COMMENT RESPONSE SUMMARY

05.10.18 LDC, INC. DVH - DAVID V. HOSTETLER, DIRECTOR OF SURVEYING

TO: Nina Ruiz, PCD-Project Manager
FROM: Elizabeth Nijkamp, P.E., PCD-Engineering
DATE: 2/26/2018.
SUBJECT: I 18-001, Rocky Top Rezone

REZONE MAP: RR-0.5 RESIDENTIAL
TO I-3 HEAVY INDUSTRIAL ZONE

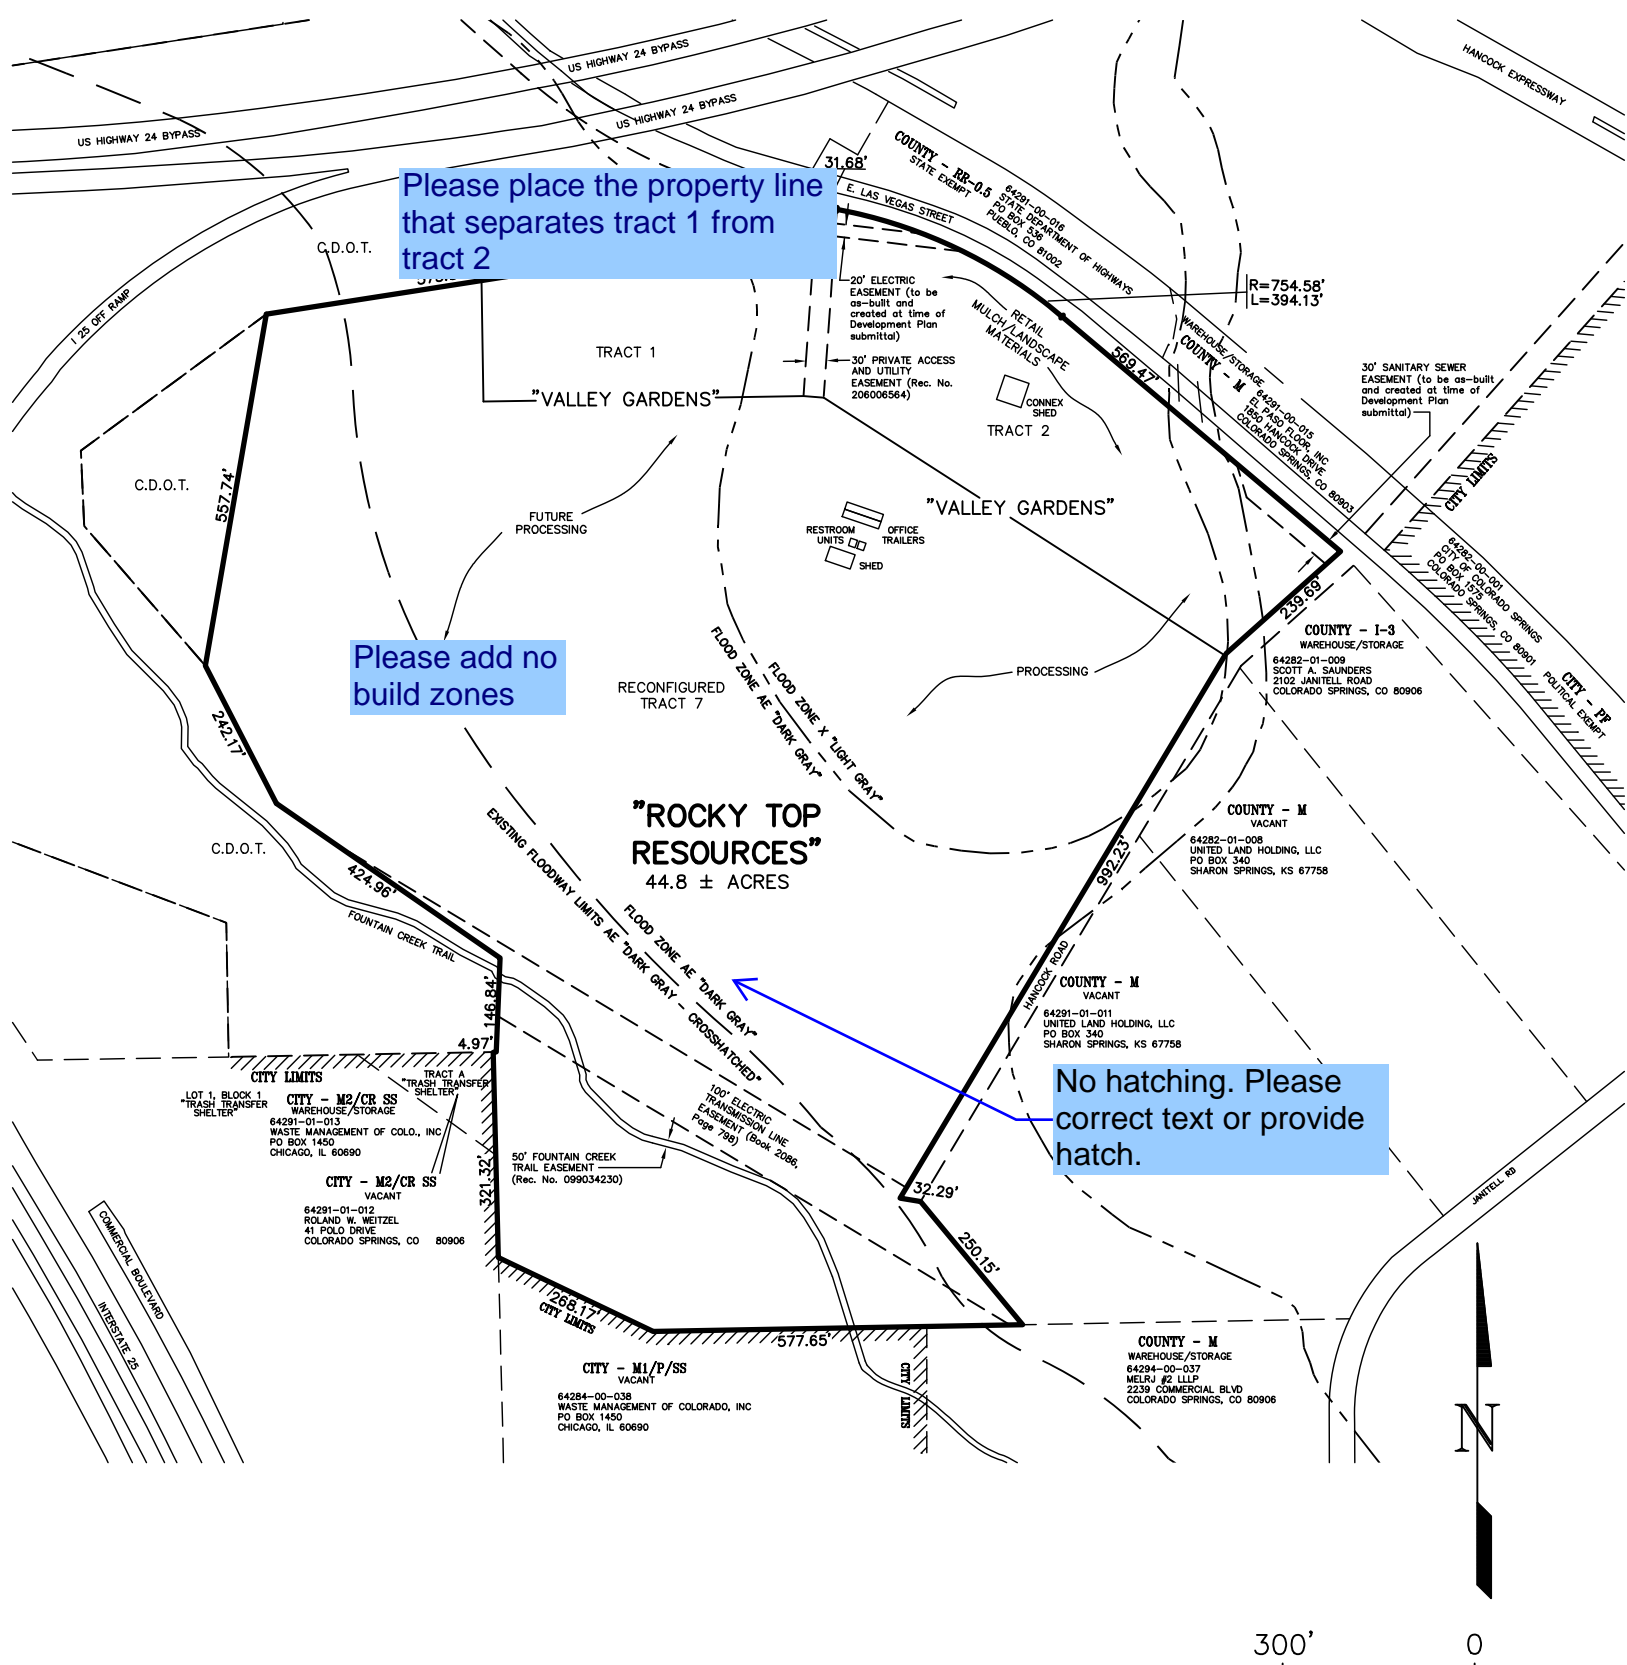
David, see attachment for a snapshot of the site with infrastructure. The green line at the northwest corner is a wastewater line that needs a 30-foot wide easement, pipe centered for the portion on the site. Also need a 20-foot wide easement for the northern powerline (in red) that extends onto the site. Also show and label the overhead powerline at the southern portion of the site with width and Reception No. Thank You

Dave, the plan you sent looks good. Please resubmit through the Planner. When I get it in my queue I will re-review and get it back as soon as possible.

Mike: Attached please find my "revised" Rezone Map Exhibit taking into consideration your Easement clarification requests. As discussed, we will detail as-built locations of existing facilities and create specific Easements at time of our upcoming Development Plan submittal. Can you review and sent an Email in general concurrence with what you see as being what you needed? Let me know if you need anything else. Thanks, DVH
